FW: 20079 - Dappers Lane Planning Consultation on: A/188/21/DOC

Further to your recent review of our information required to discharge planning conditions, we are pleased to provide the updated information on the following link; <https://we.tl/t-Os1XI0r1nn>.

Drawing Status	CONSTRUCTION
Scale	A1
Date	October 2020
File	20079/dwgs/civils/current
Drawn	LJ
Checked	
Drawing	
20079 - 326 E

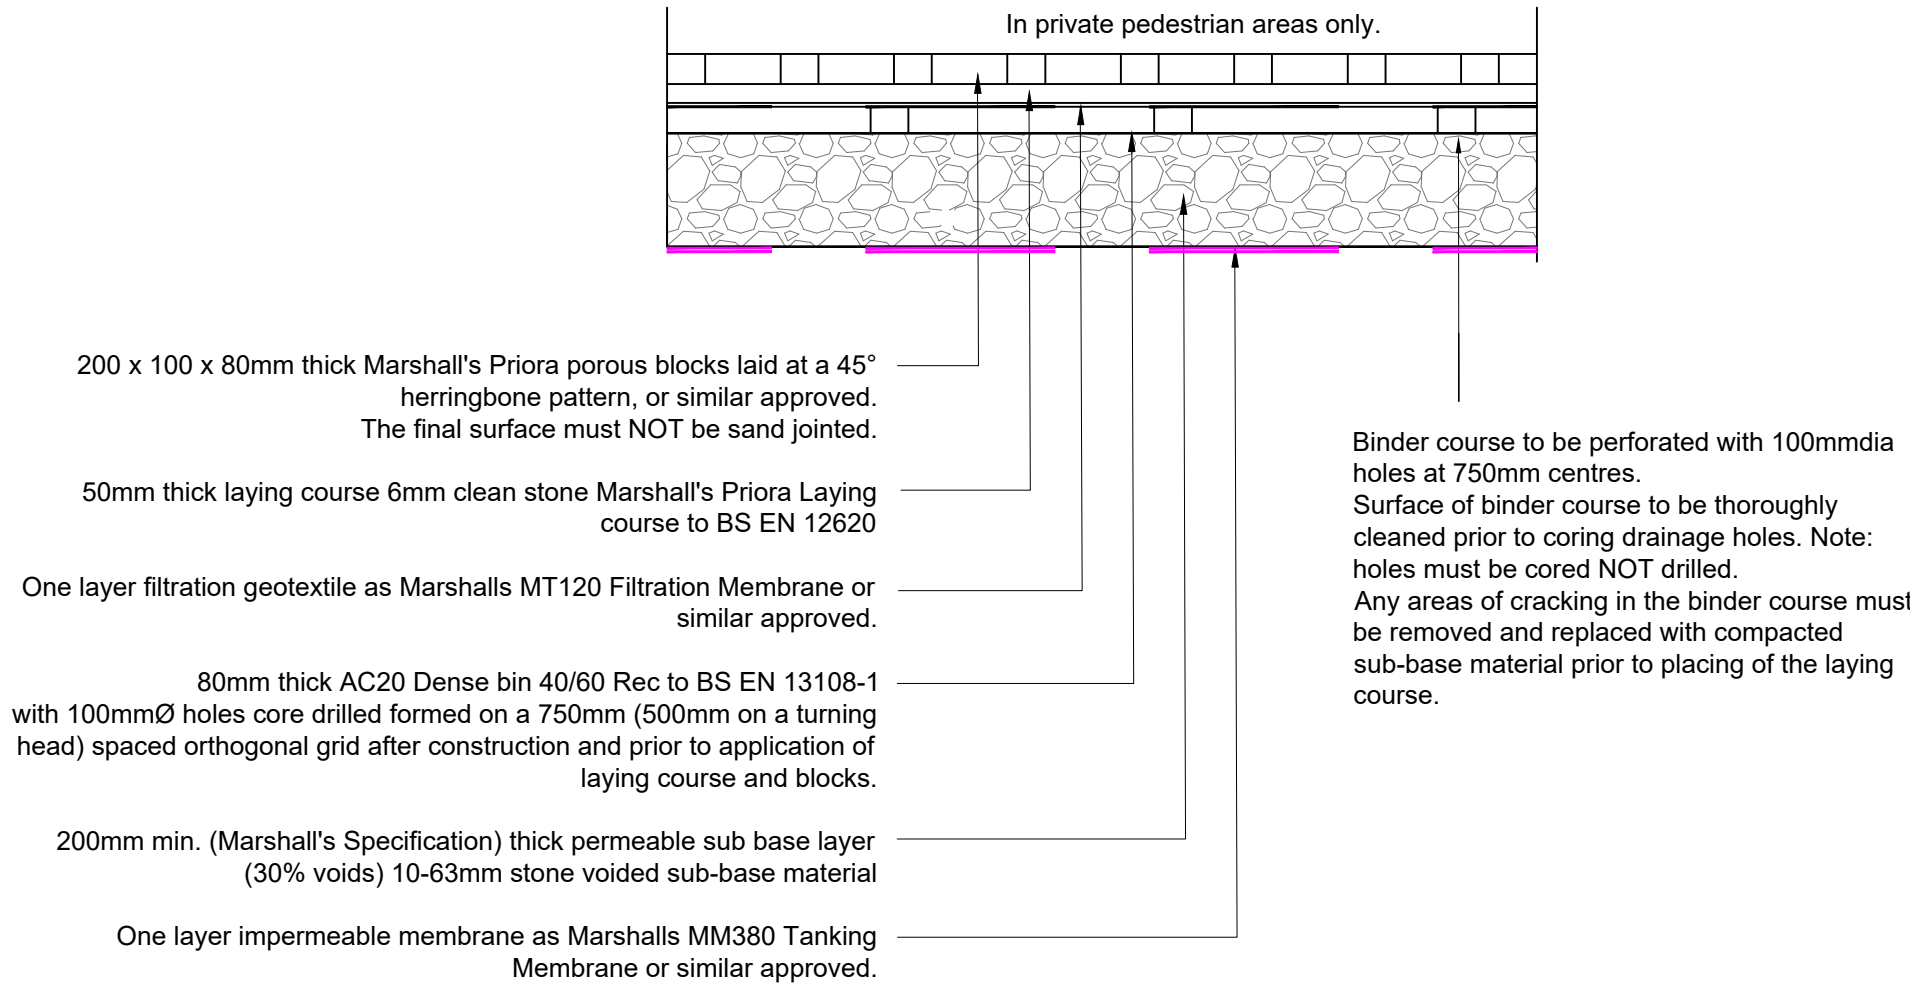
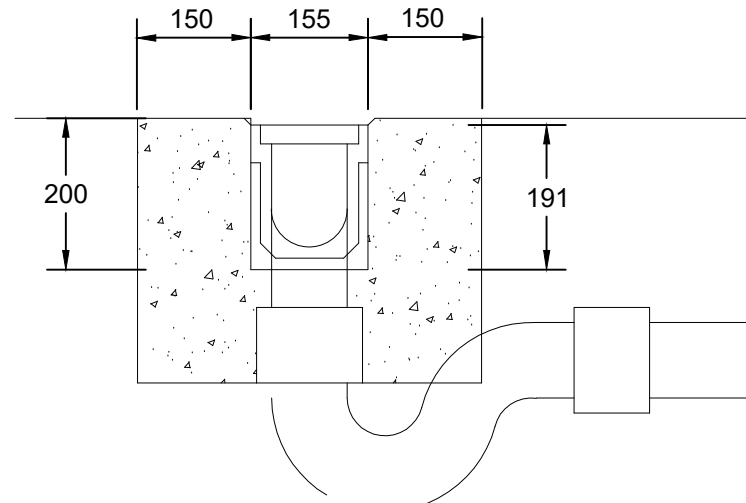
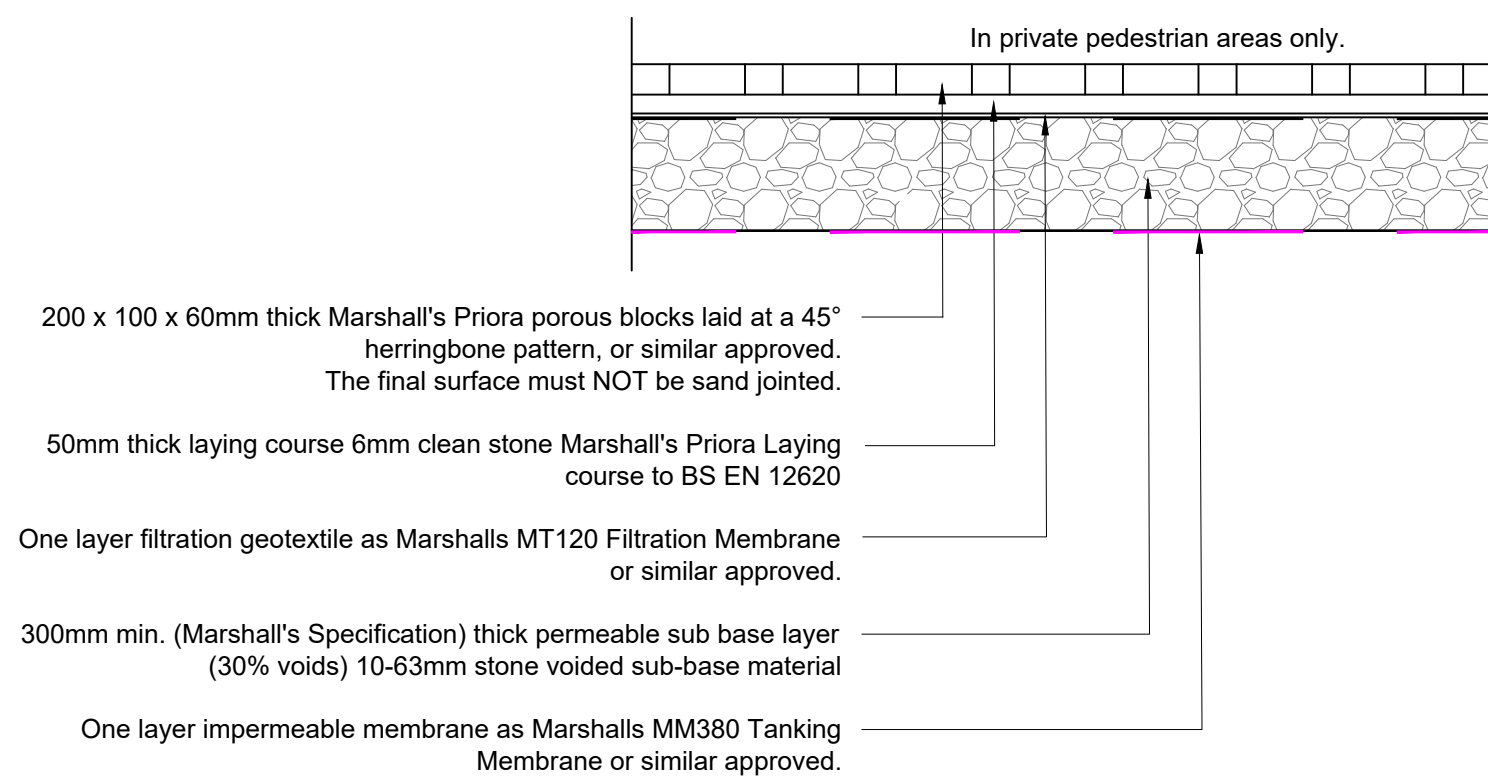
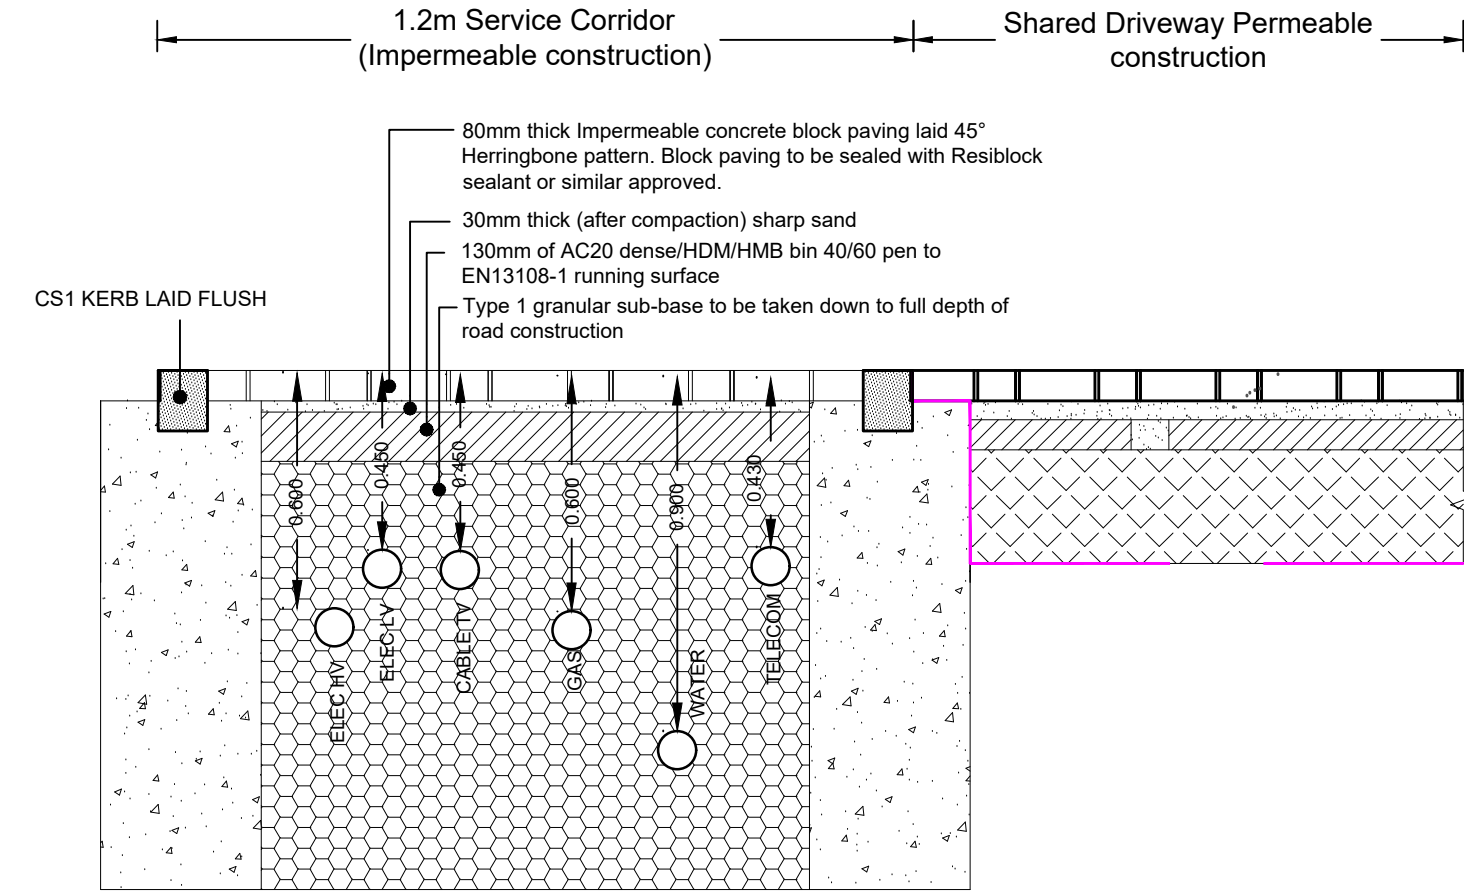
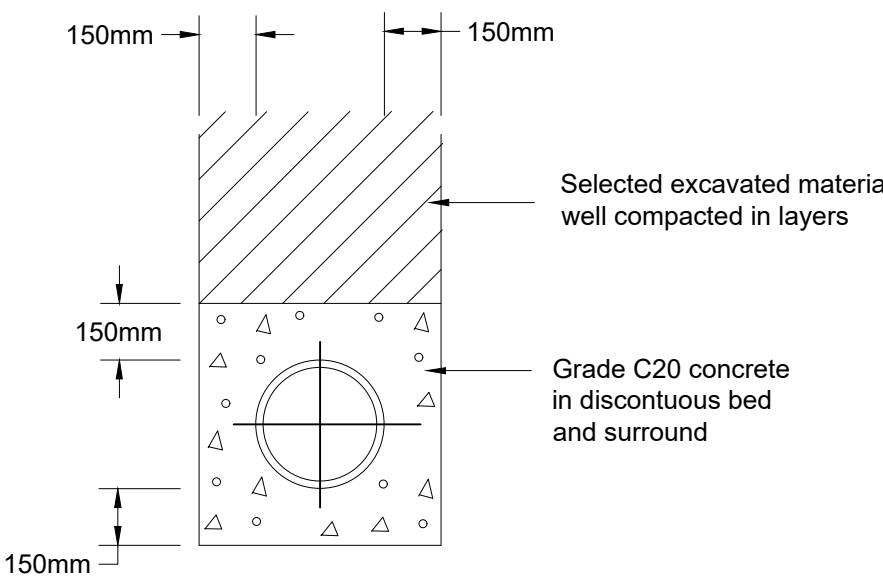
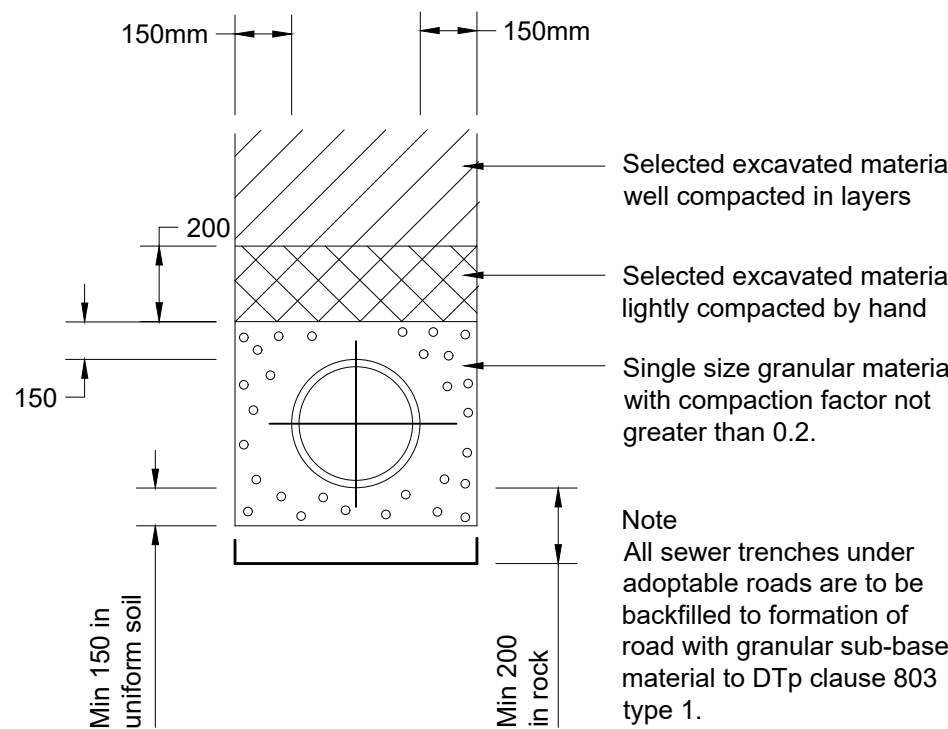
15. Please provide full construction detail drawings. Please provide construction detail drawings of catchpits, ACO drains, permeable paved roads, etc.

Please detail what bed and surround requirements are for pipes outside of adoptable highways. – Bed and surround detail added to private drainage details.

BGC 30/08/21 – Full set of Construction Details provided within latest submission including ACO drains and permeable paved roads. Please refer to drawings; 20079/311, 20079/315, 20079/316, 20079/320, 20079/321, 20079/322, 20079/326, 20079/327, 20079/330 & 20079/331.
